Date: 23 October 2023  
Our Ref: 23/00849/FULHH  
Please ask for: Simon Lems

## Invalid Application

**Proposal:** Re-roofing of front elevation  
**Location:** 31 Withnell Fold Withnell Chorley PR6 8BA  
**Reference:** 23/00849/FULHH

LOCATION PLAN 1 : 1250

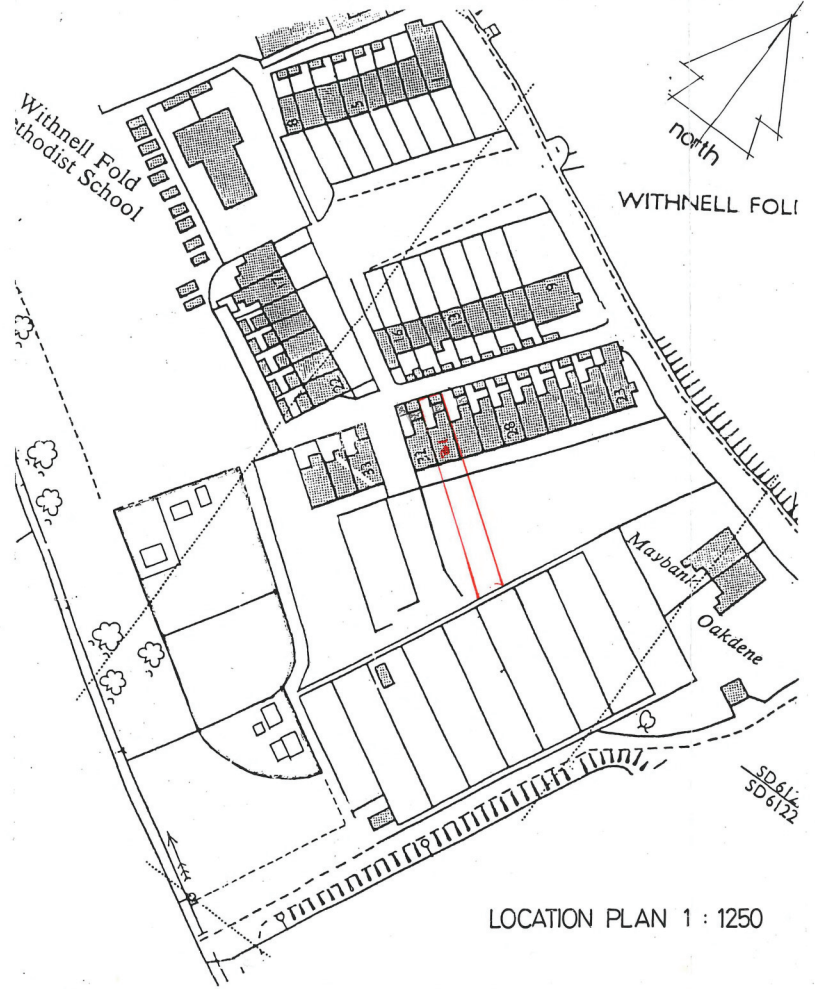
### 1. Location plan (a plan which identifies the land to which the application relates)

The location plan should clearly identify the application site. The plan will be required to be based on an up-to-date map at a scale of 1:1250 or 1:2500. In exceptional circumstances plans of other scales may also be required. The plan should include a least two named roads and the surrounding buildings. The buildings should be numbered/ named to ensure that the application site is clearly identified.

The application site should be edged clearly with a red line. It should include all land necessary to carry out the proposed development (e.g. land required for access to the site from a public highway, visibility splays, landscaping, car parking and open areas around buildings.) A blue line should be drawn around any other land owned by the applicant, close to or adjoining the application site.

(1:50) FRONT ELEVATION - 31 WITH NELL FOLD

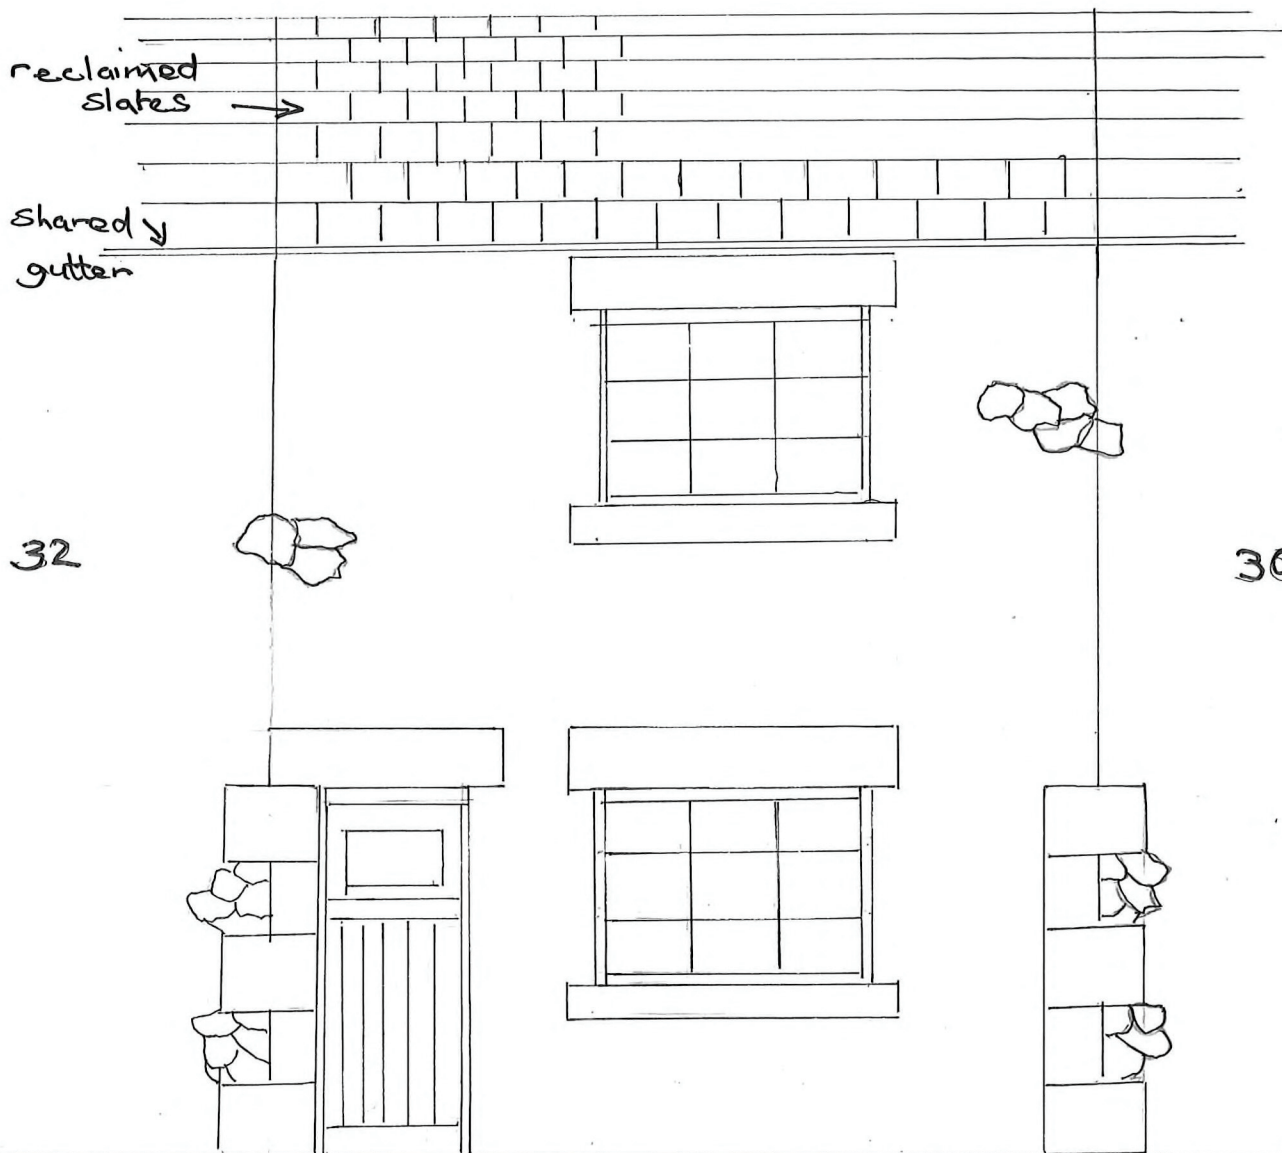
### 2. Existing and Proposed Elevations (at a scale of 1:50 or 1:100)

These should be drawn to a scale of 1:50 or 1:100 and show clearly the proposed works in relation to what is already there. All sides of the proposal must be shown and these should indicate, where possible, the proposed building materials and the style, materials and finish of windows and doors. Blank elevations must also be included; if only to show that this is in fact the case.

Where a proposed elevation adjoins another building or is in close proximity, the drawings should clearly show the relationship between the buildings and detail the positions of the openings on each property.

The submitted plans should include the dimensions of the proposal annotated onto the plan.

In this instance we will require elevations of the property showing the previous roof and the new proposed roof.
